**Re: Machine Shop/Warehouse, 1618 2nd Street NW
Traffic Circulation Layout – Engineer's Stamp dated 6-17-05 (J14-D107)**

PROJECT TITLE: MACHINE SHOP / WAREHOUSE ZONE MAP/DRG. FILE #: J-14/D107
 DRB #: 1003702 EPC#: — WORK ORDER#: —

PROJECT TITLE:
MACHINE SHOP/WAREHOUSE
1618 2 ND STREET N.W.
SHEET TITLE:
TRAFFIC CIRCULATION LAYOUT

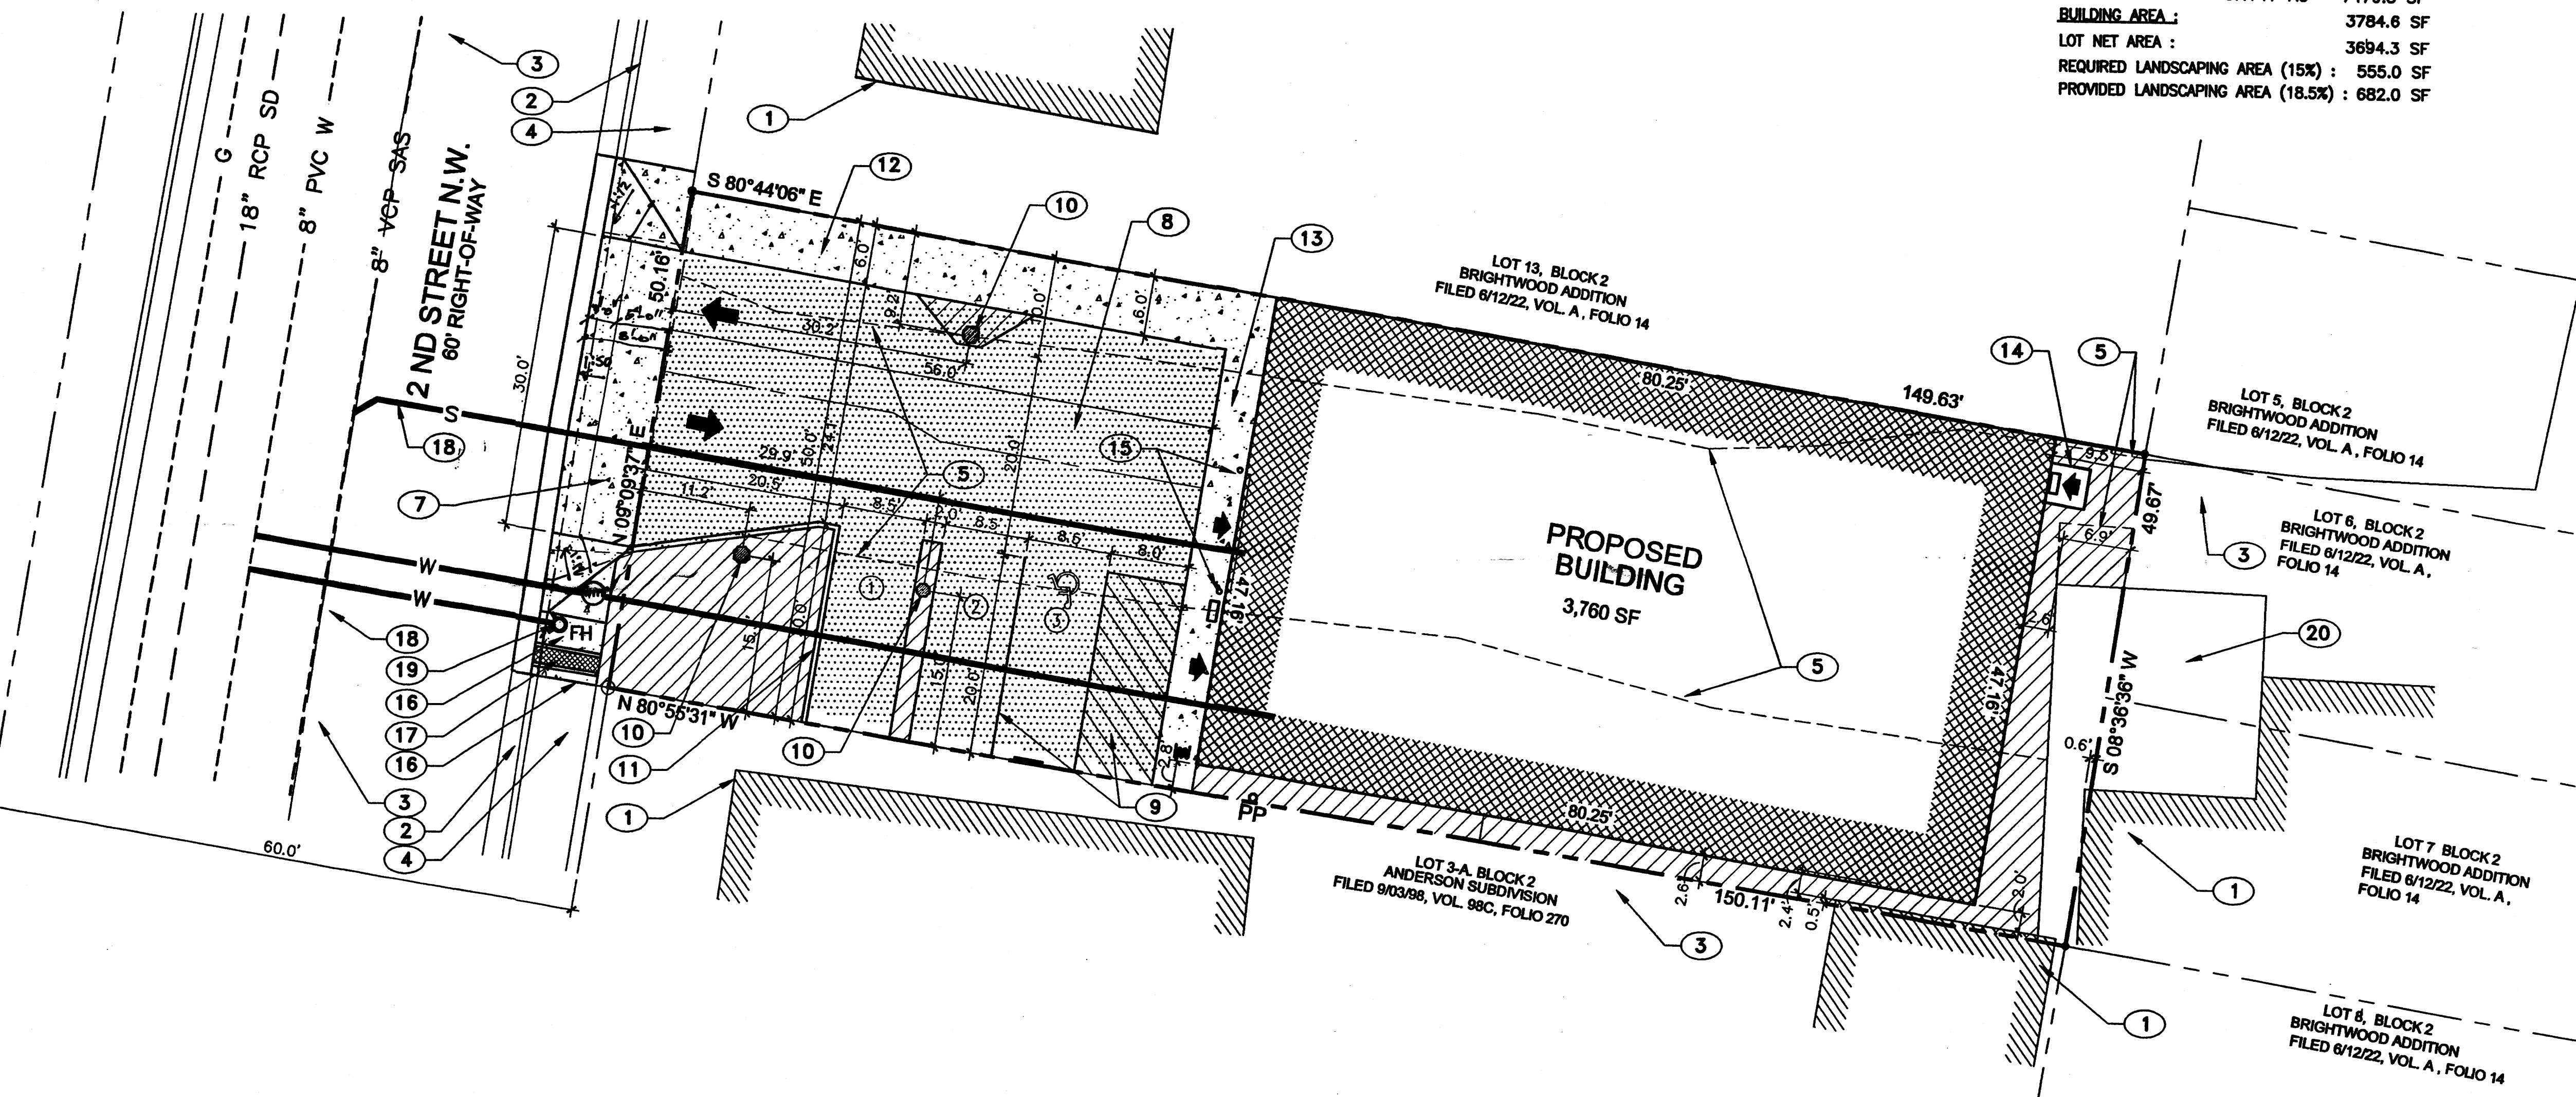
- Provide detail showing how ADA access works across drivepad.
- Existing tree at northern edge of proposed parking is encroaching on the minimum aisle width of 24'.
- Provide curbing around existing tree at southern edge of proposed parking.
- Van accessible aisle needs to be on the passenger side of the van parking space.
